October 12, 2015

**Re: Freddy's Coors and Central  
Erosion Sediment Control Plan  
Engineer's Stamp Date 10-5-15 (K10E001B)**

FREDDY'S COORS AND CENTRAL	DRAWN BY B.J.F.
	EROSION AND SEDIMENT CONTROL PLAN	DATE 9/10/15
	 TIERRA WEST, LLC 5571 MIDWAY PARK PLACE NE ALBUQUERQUE, NM 87109 (505) 858-3100 www.tierrawestllc.com	2015036-SWPPP
	RONALD R. BOHANNAN P.E. #7868	SHEET # ESC-1 JOB # 2014075

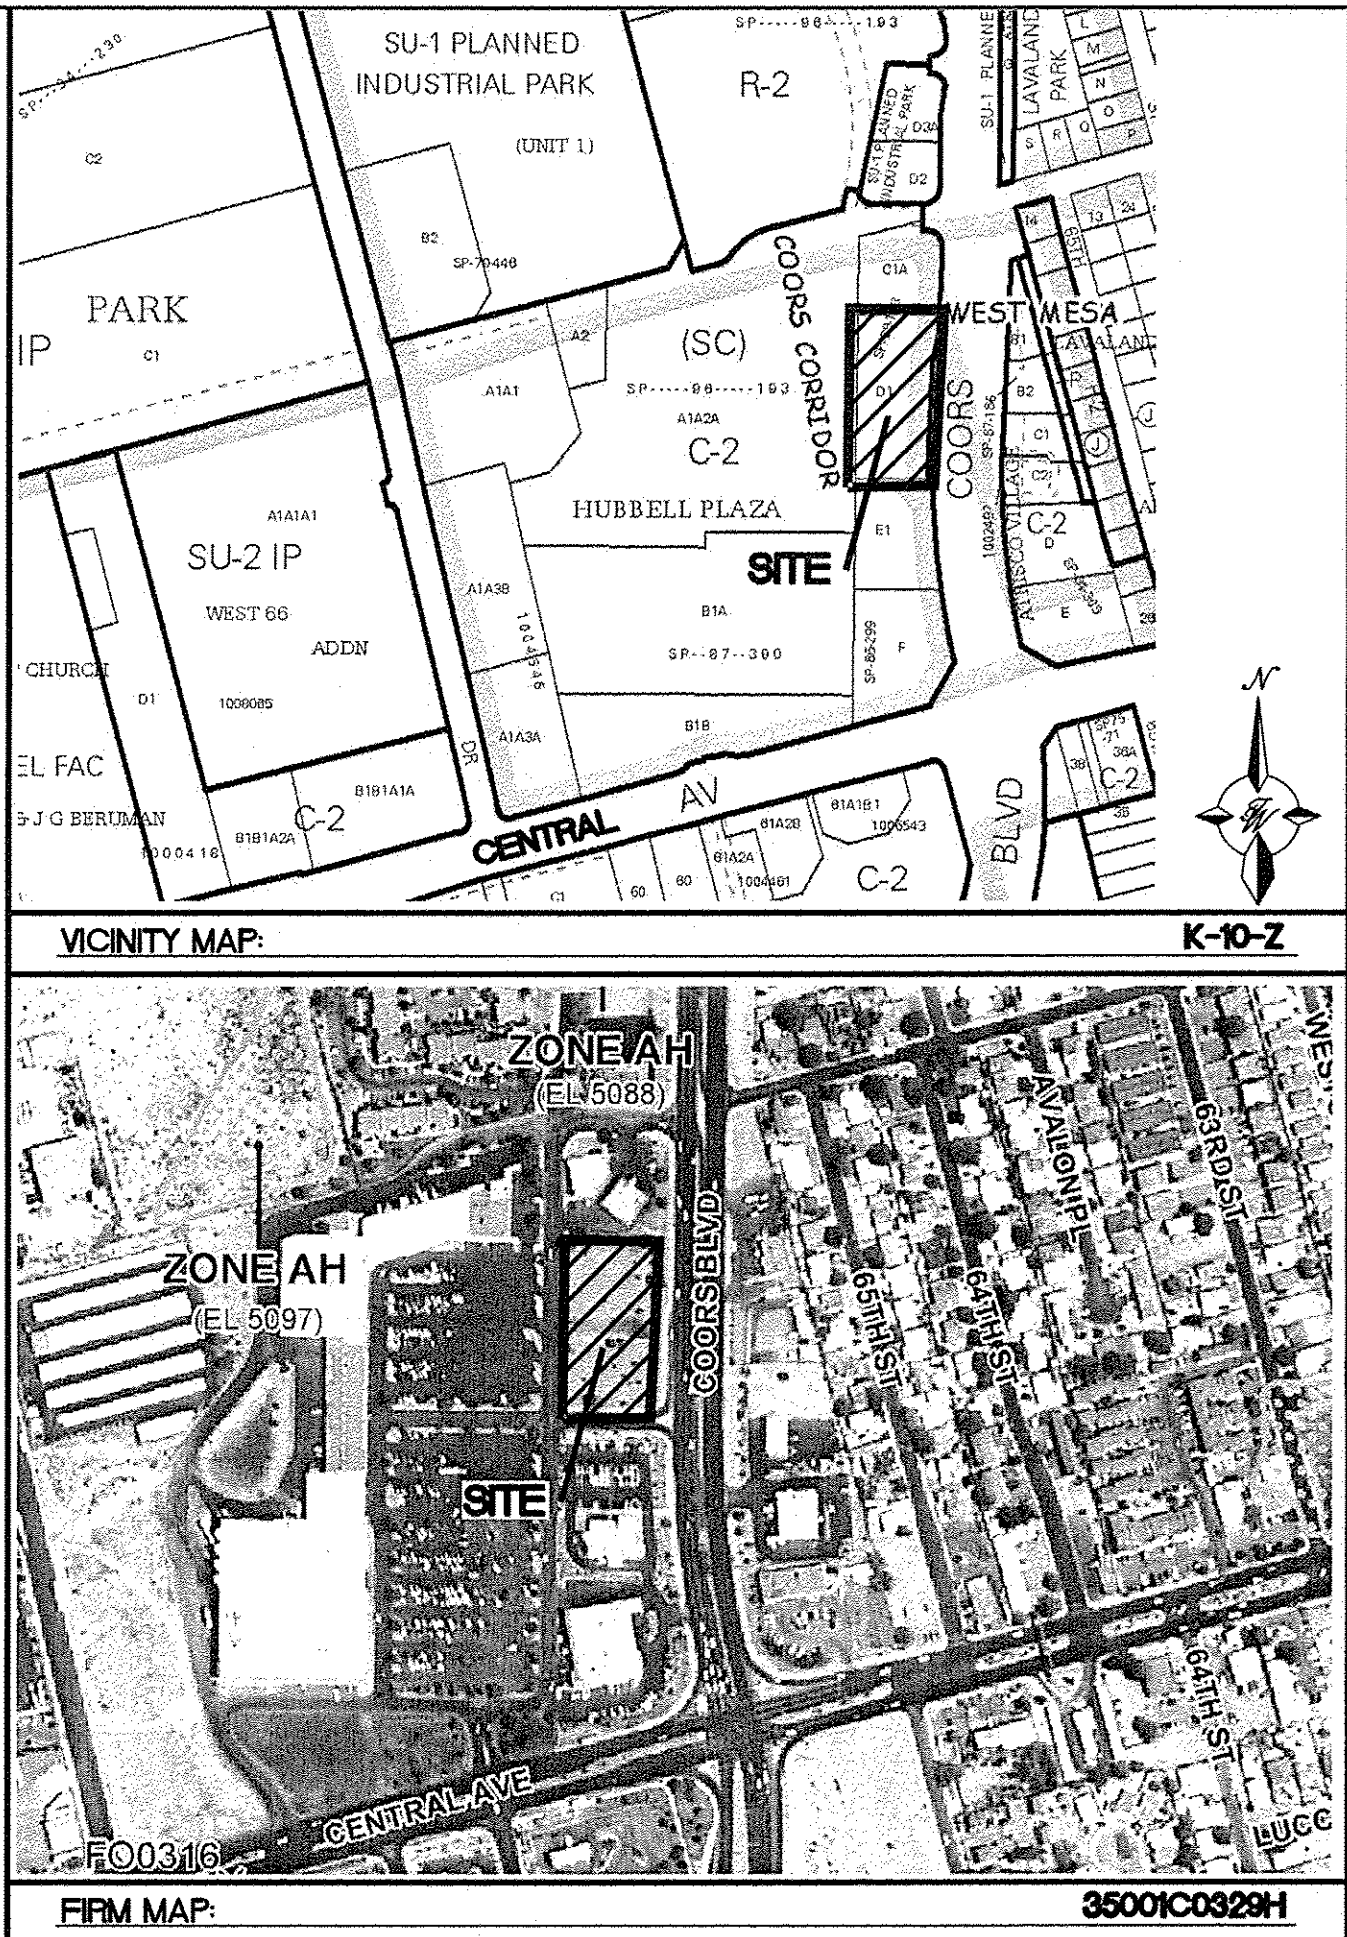
It may be better to put the construction entrance on the west side of the site rather on Coors Blvd that way track-out, if any, would stay on-site rather than migrate onto Coors Blvd.
